**RE: State Significant Development (SSD 9619) – Tilbuster Solar Farm Lot 1 DP 225170, Lot 1 DP 585523, Lot 3 DP 800611, New England Highway, Tilbuster.**

### **Transport for NSW Response**

Tilbuster Solar Farm
 New England Highway / Site Access Intersection
 Swept Path Assessment

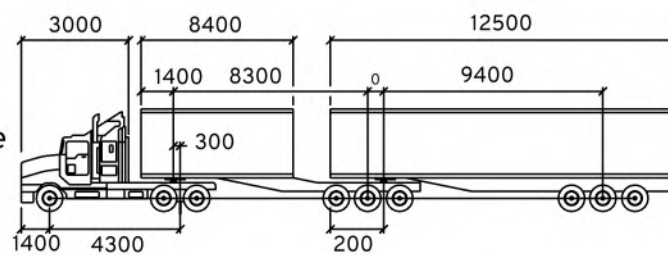
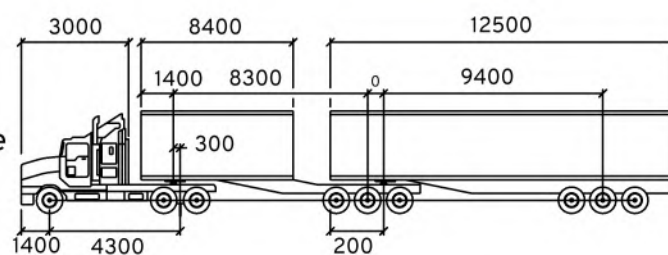
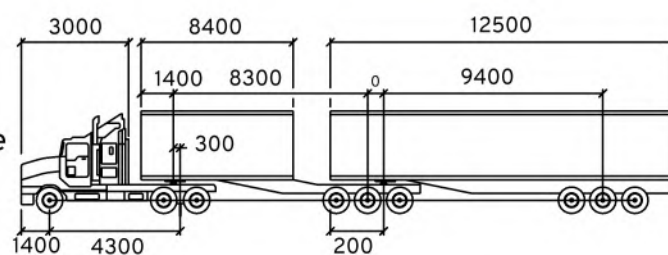
- The internal access road, site access intersection, manoeuvring areas and parking areas should be suitable for the relevant design vehicles. It should be noted that the Swept Paths provided for the site

access intersection are for a 19m Single Articulated Vehicle (AV), however, a 19m B-Double is often referred to throughout the EIS and TIA as an alternate design vehicle.

The Single AV swept path appears to demonstrate very little room for readjustment or clearance between vehicles when a Single AV is turning into the site access and another is in a stationary position preparing to exit. The swept path of a B-double will be different to the Single AV and is required in addition to the Single AV to clearly demonstrate that the vehicle can successfully complete the required movements without crossing the centre-line of both the New England Highway and the site access road, therefore ensuring the proposed upgrades will accommodate both of the key proposed design vehicle/s.

TfNSW recommend that the Consent Authority request further Swept Path assessments be undertaken for the B-Double vehicle (and any other OSOM vehicle, if applicable). The site access design should be amended, if warranted by the additional swept path/s and the internal realigned road be widened to comfortably accommodate the clear movement of two way traffic for the largest design vehicles.

Tilbuster Solar Farm
New England Highway / Site Access Intersection
Swept Path Assessment - OSOM Vehicle

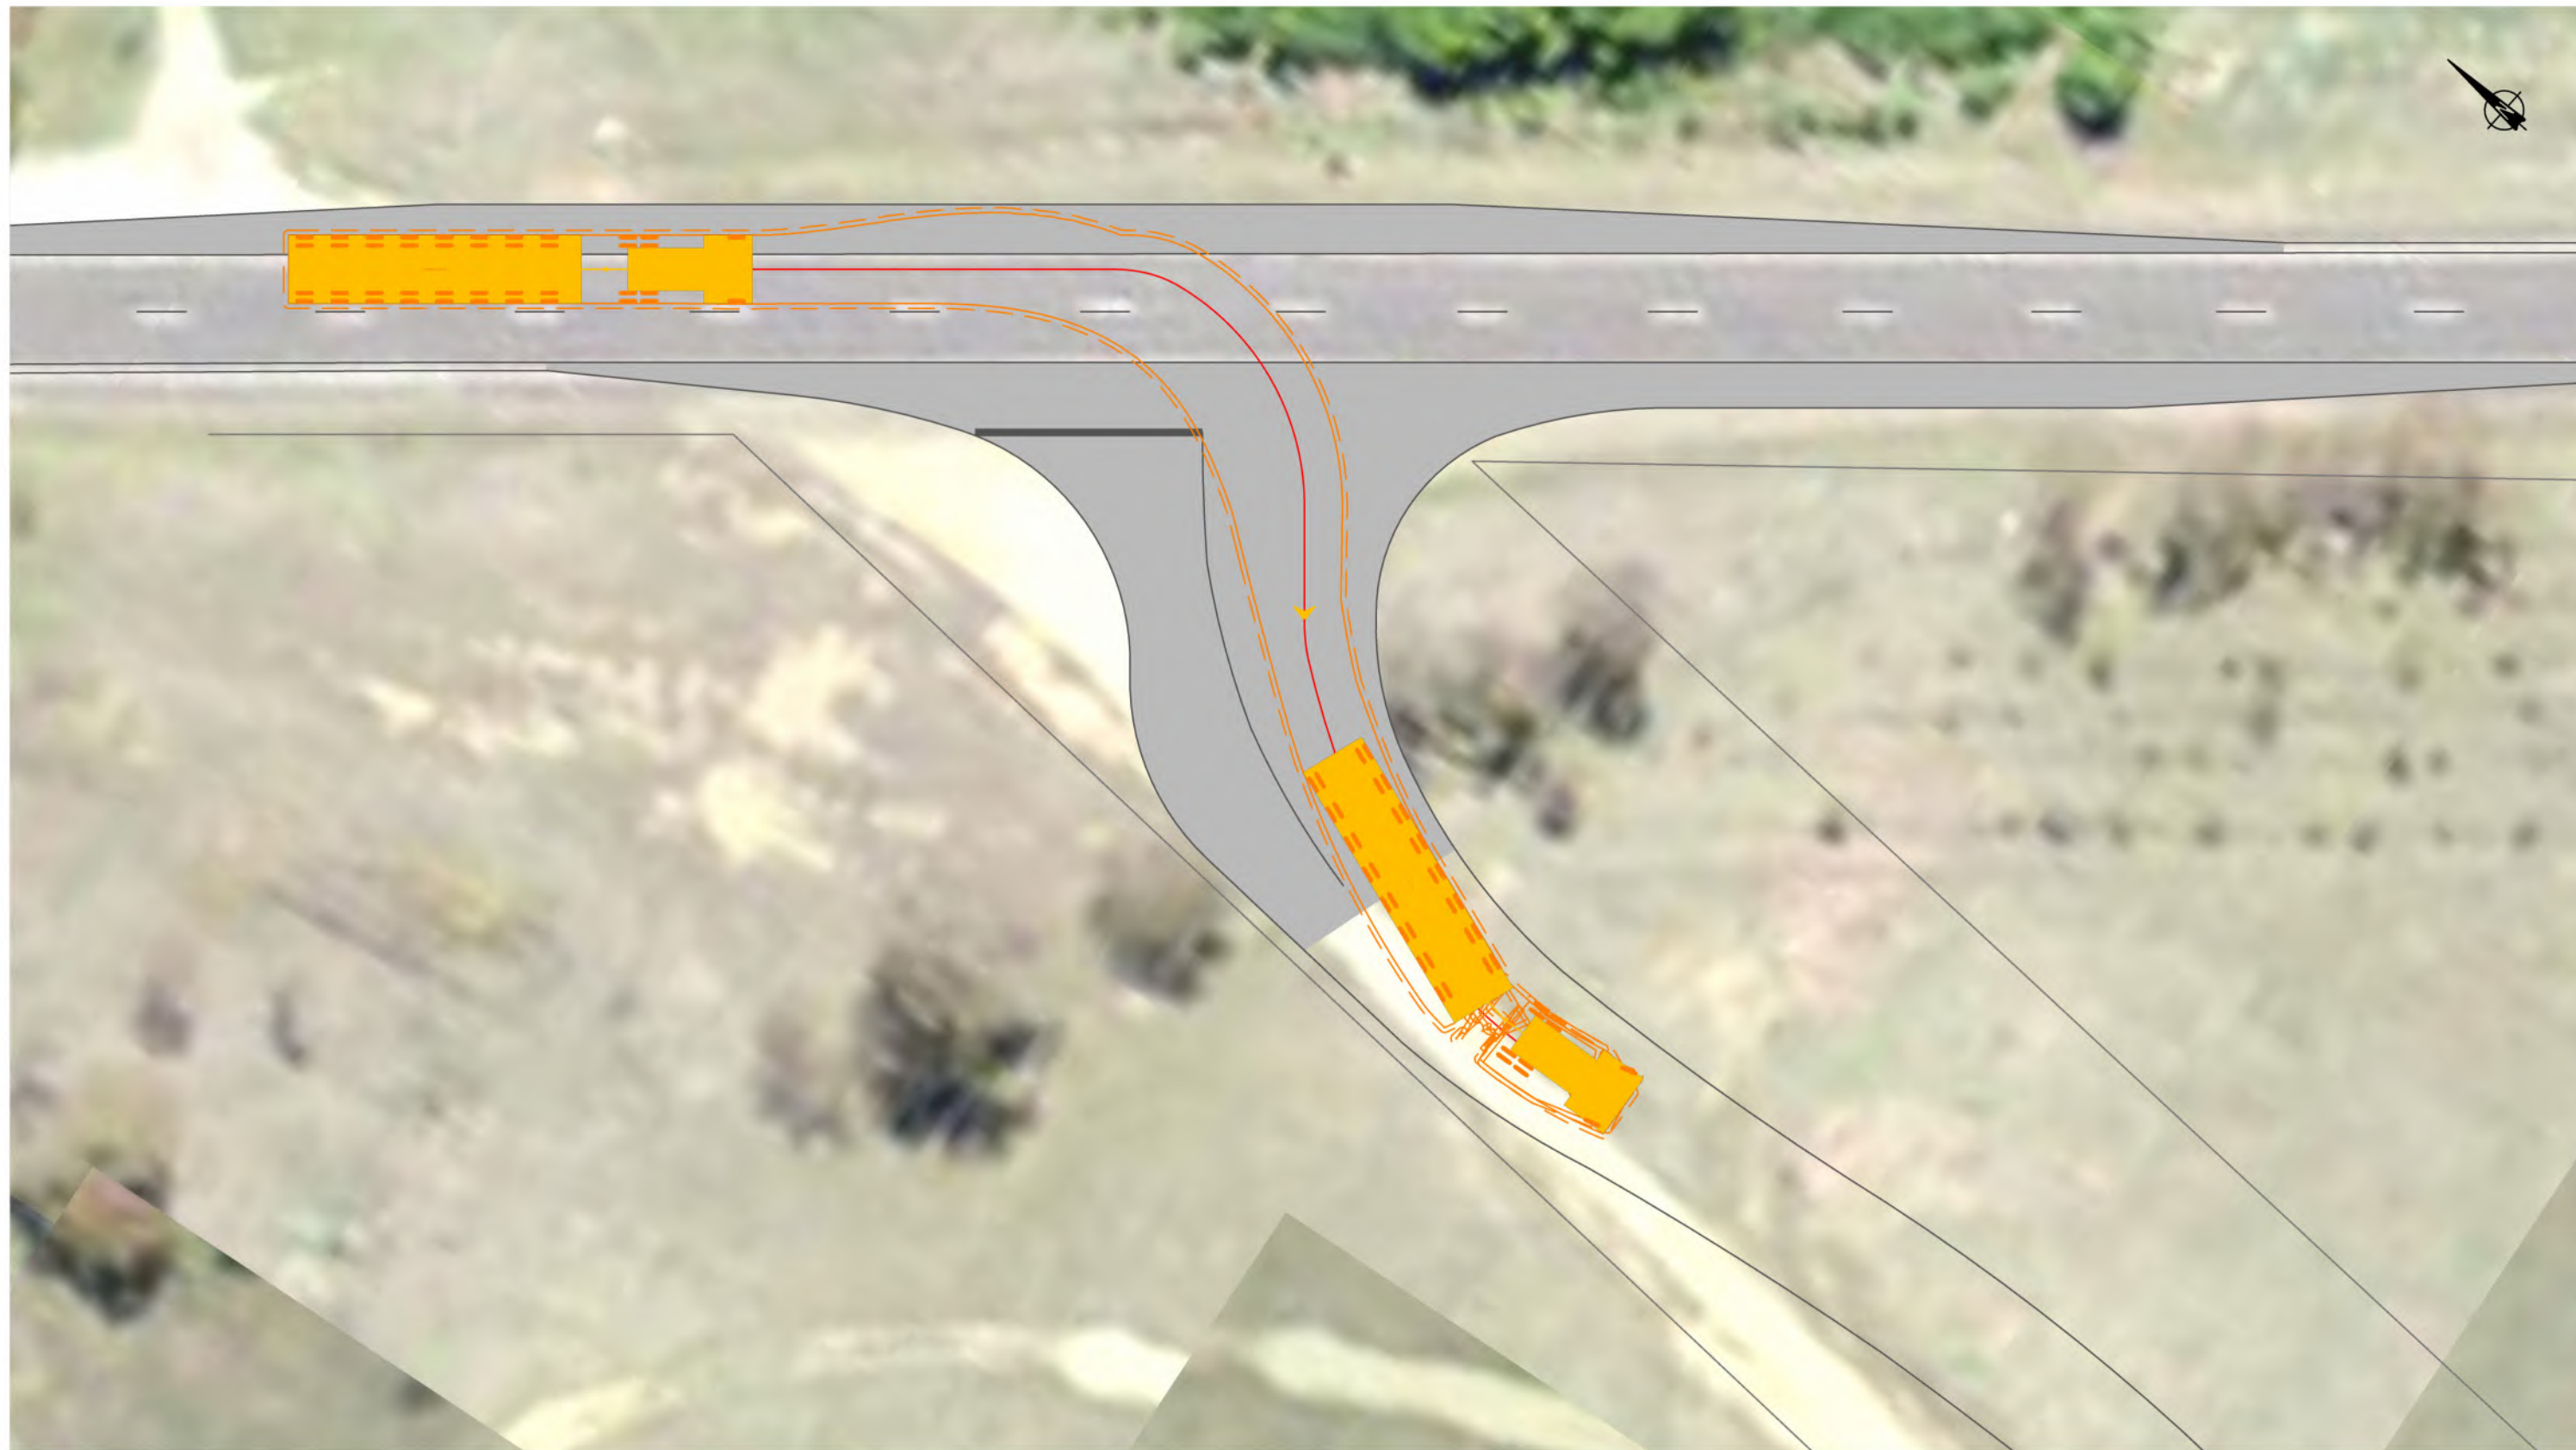
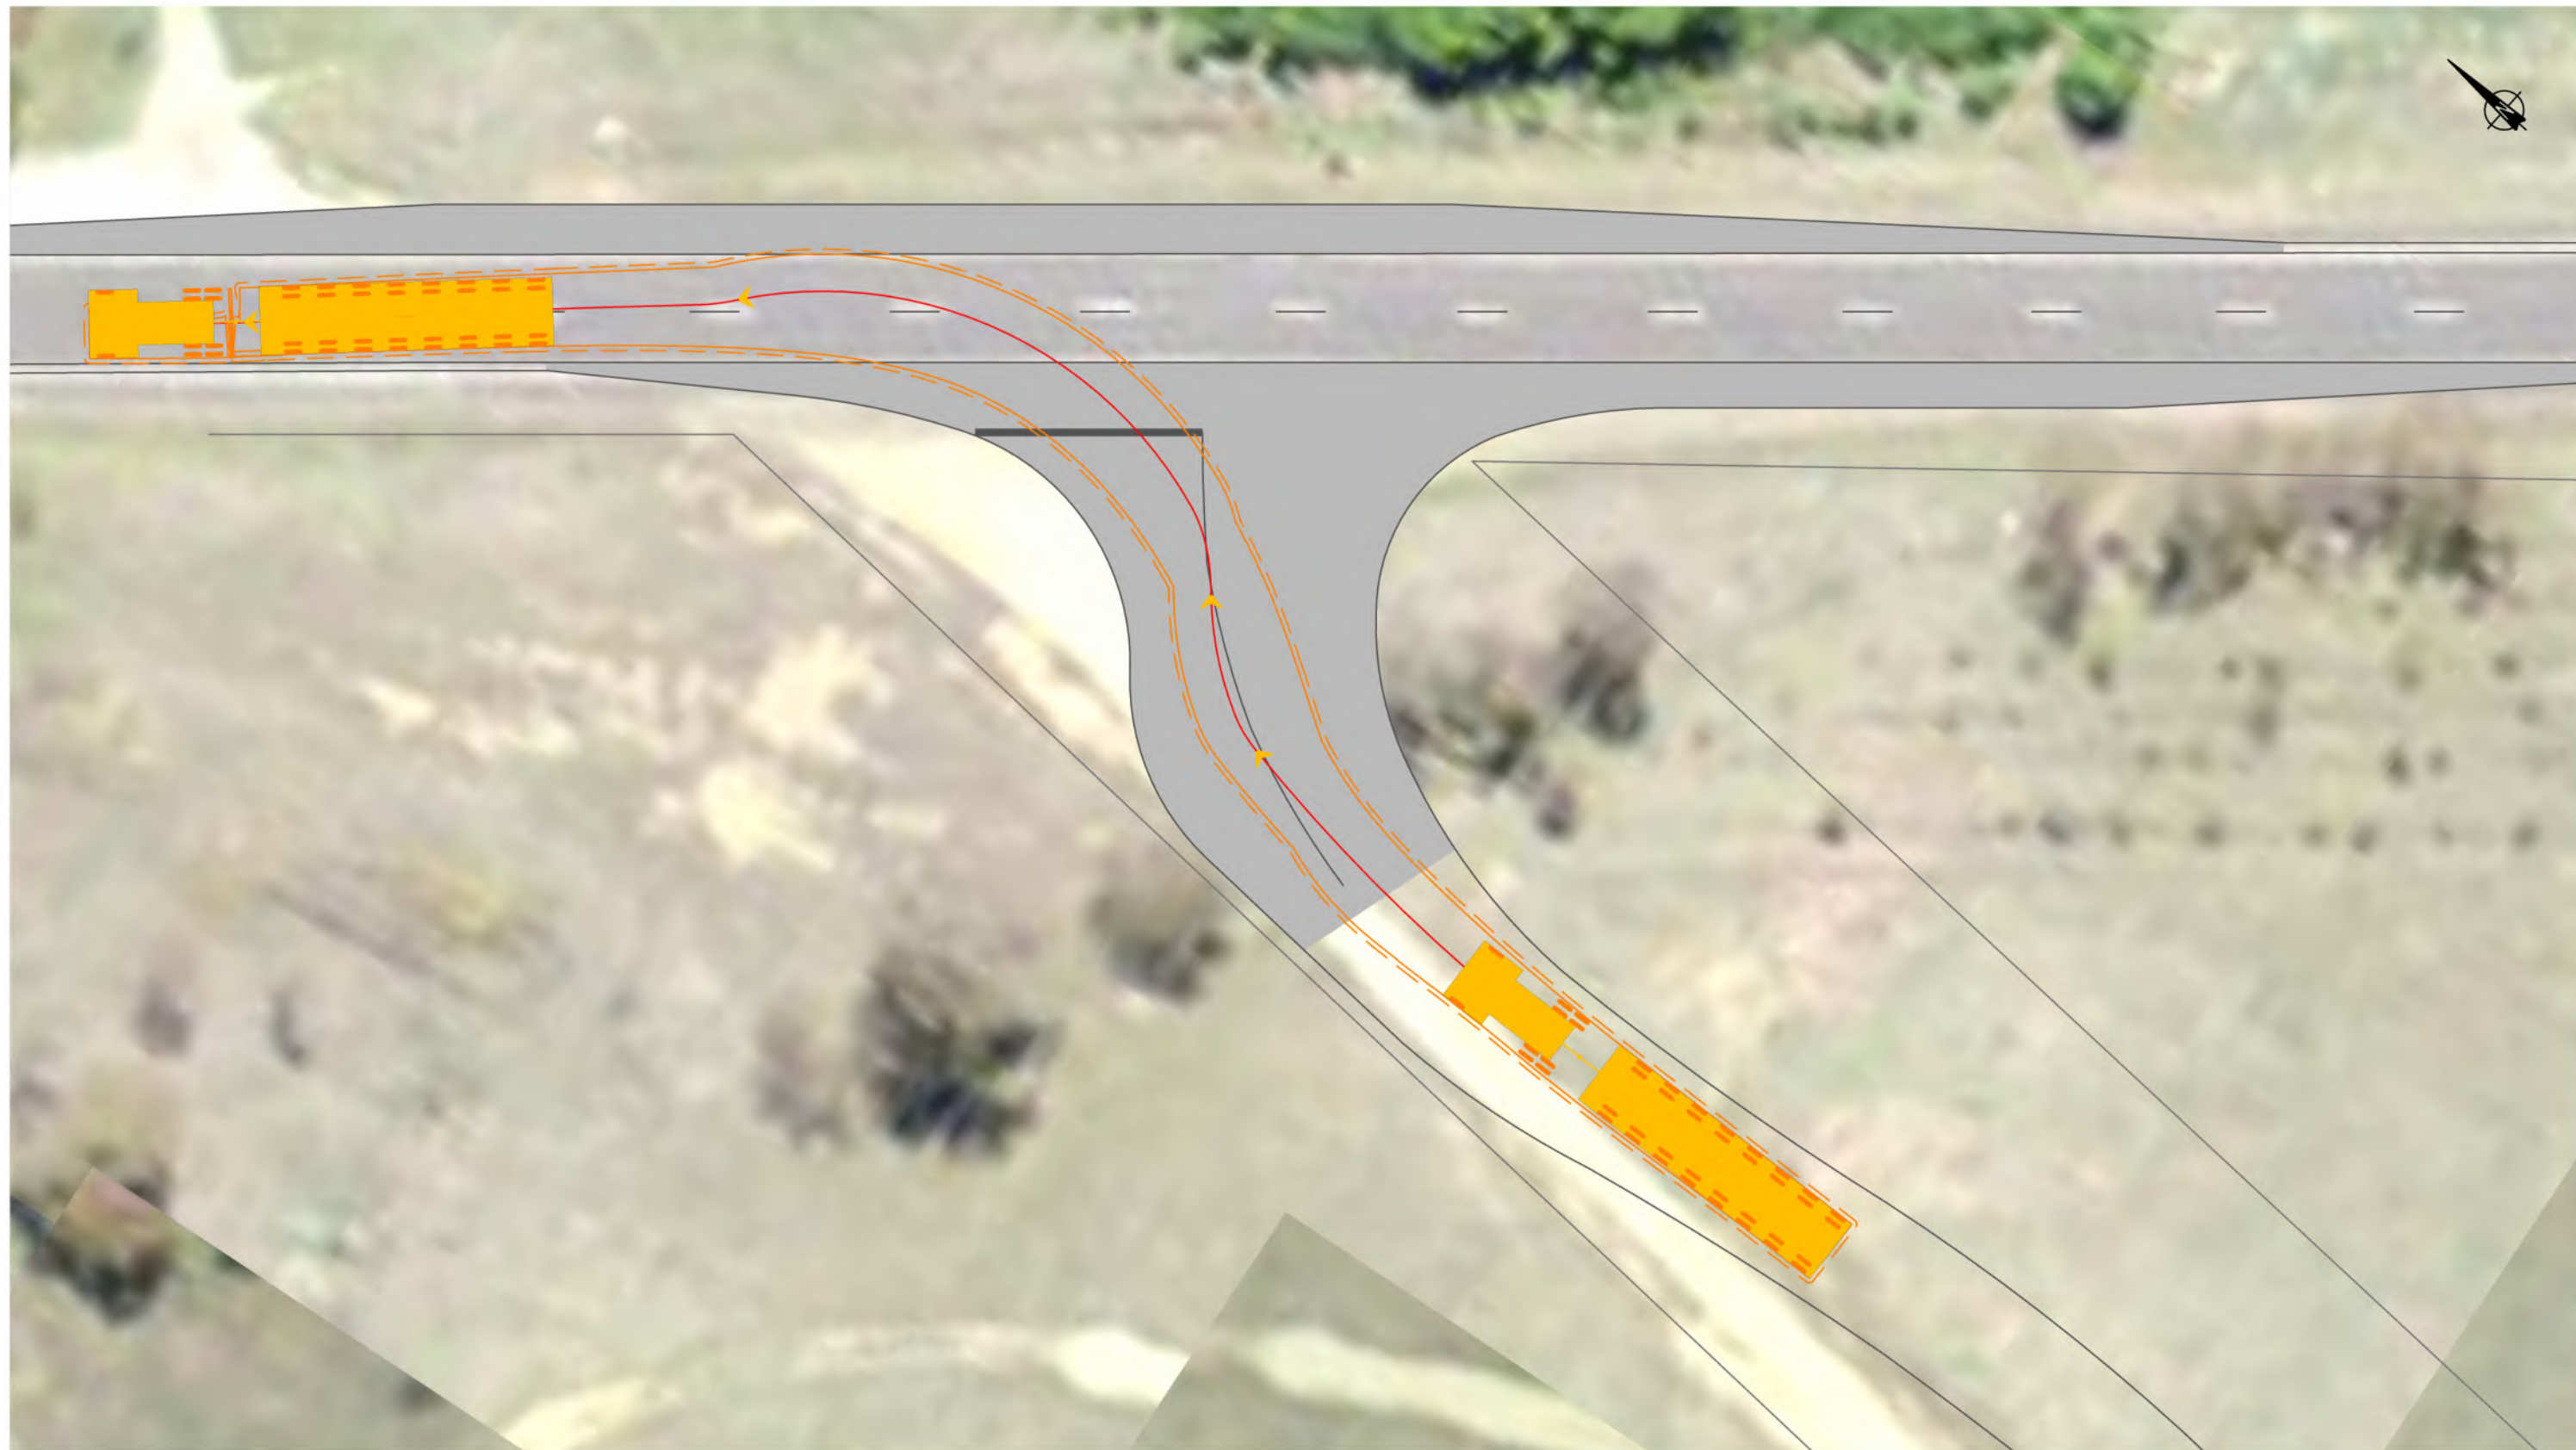
- TfNSW notes, that the Transformer(s) and 200 Tonne Crane(s) will require Over-Size Over-Mass (OSOM) specialist vehicles to be transported to site, however the vehicle types, dimensions, weights and configurations of the loads have not been provided or clarified. Furthermore, it is unclear if the OSOM items will also be transported along the same proposed haulage route as the bulk of the materials from Port Botany. This information should be included in the CTMP, addressing any pinch points (including a Route Assessment and bridge assessment, if applicable), providing explanation on how risks and movements will be mitigated.

TfNSW recommend that the Consent Authority request the OSOM loads be addressed further in the CTMP and that further assessment be undertaken to provide additional information in regards to the proposed haulage of components, construction materials and / or machinery from the two identified regions. This should include but not be limited to, the vehicle specifications, load dimensions & weights (for OSOM), the expected haulage routes, including assessment of any key intersections or bridges where applicable, and the trips generated by the identified haulage activities. This additional information should be included in the EIS, TIA and CTMP for further review prior to determination.
